**New Primary School at Googong (SSD-10326042)
Response to submissions report**

ATTACHMENT 1 – KEY ISSUES

APPENDIX A – PROPOSED WASTE STORAGE AREA LOCATION

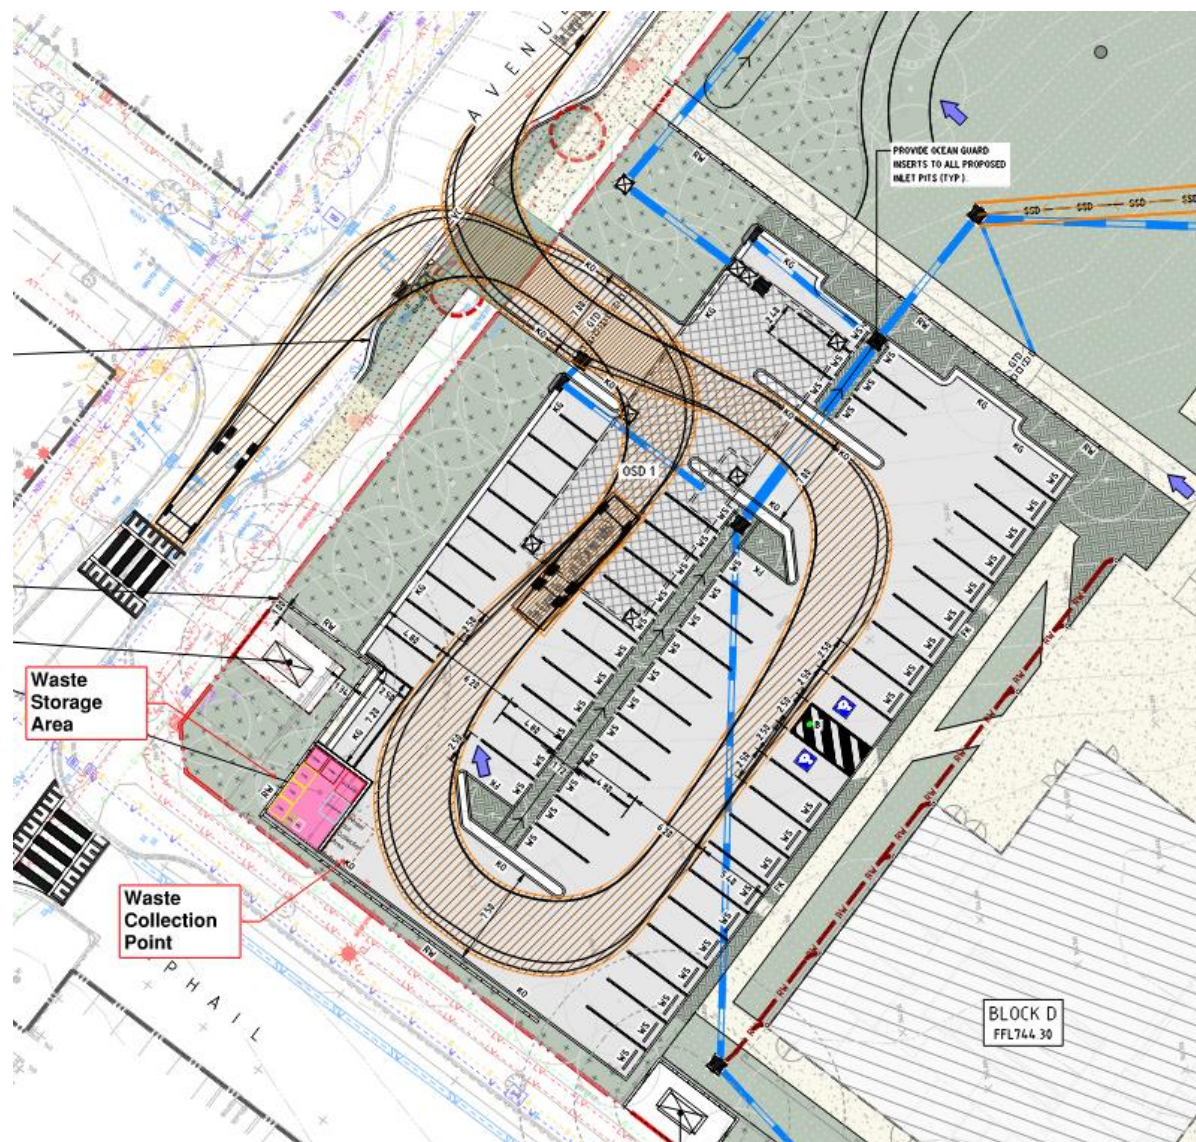
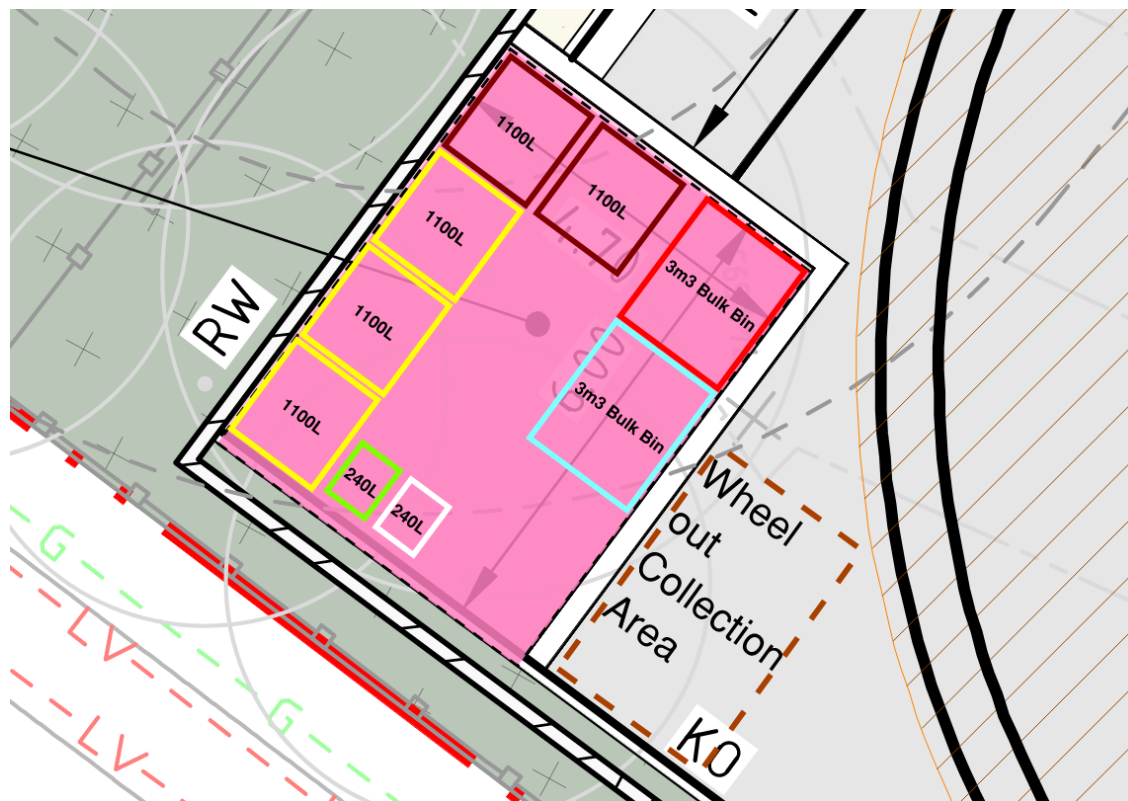
- Demonstrate that the proposed waste storage facilities would be appropriately separated from the on-site carparking and would not interfere with pick-up and drop-off of school children.
